BRANDING IRON AT STERLING RANCH FILING NO. 1

STREET IMPROVEMENT PLANS

NOVEMBER 2017

SF-17-024

BRANDING IRON AT STERLING RANCH FILING NO. 1
 STREET IMPROVEMENT PLANS
 PROJECT NO. 09-006
 DATE: 10/22/2018
 SCALE: HORIZONTAL: 1"=50' VERTICAL: 1"=5'
 DESIGNED BY: JP
 DRAWN BY: ELY
 CHECKED BY: GW
 SHEET 3 OF 8
 S103

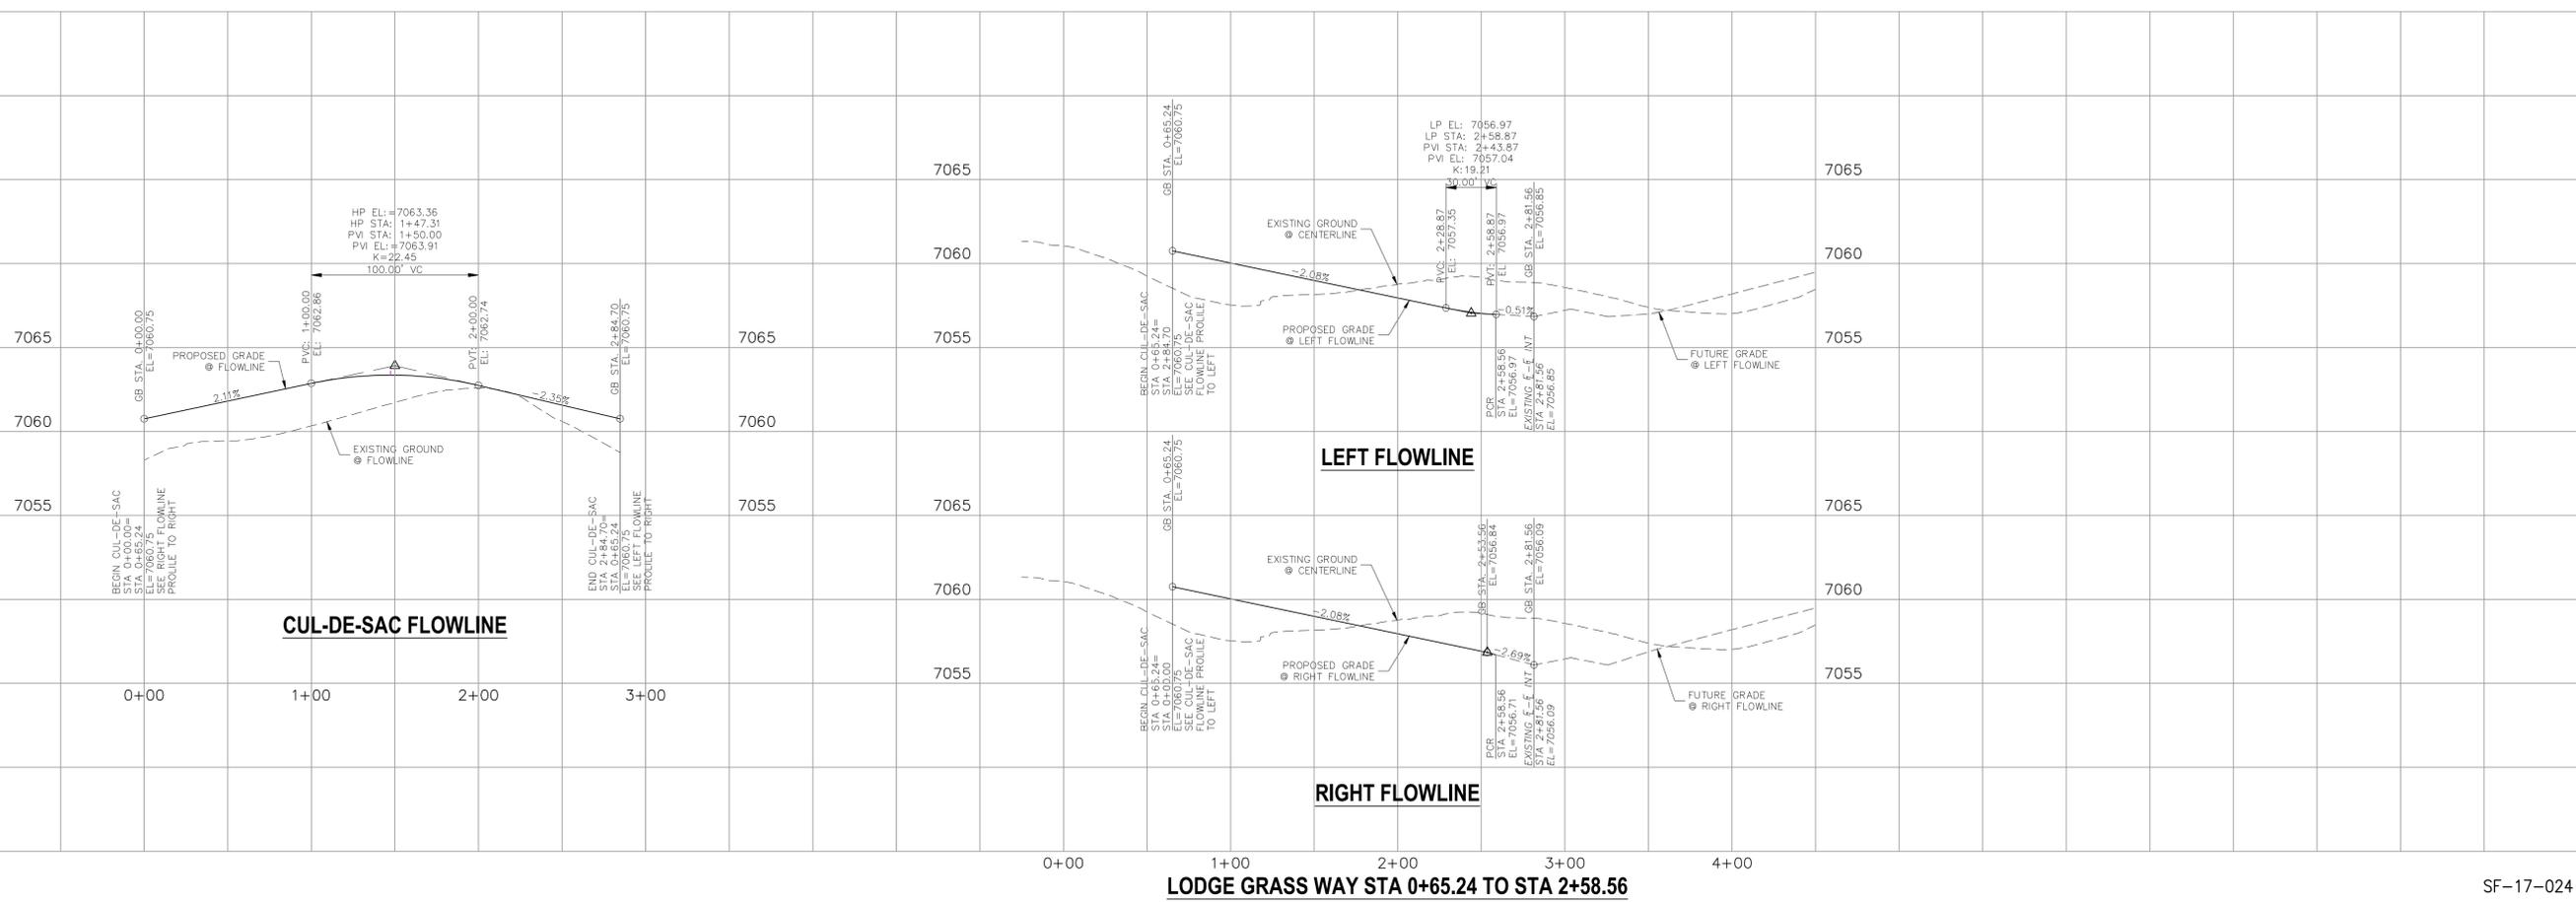
Optional Type C?
(Recommended)
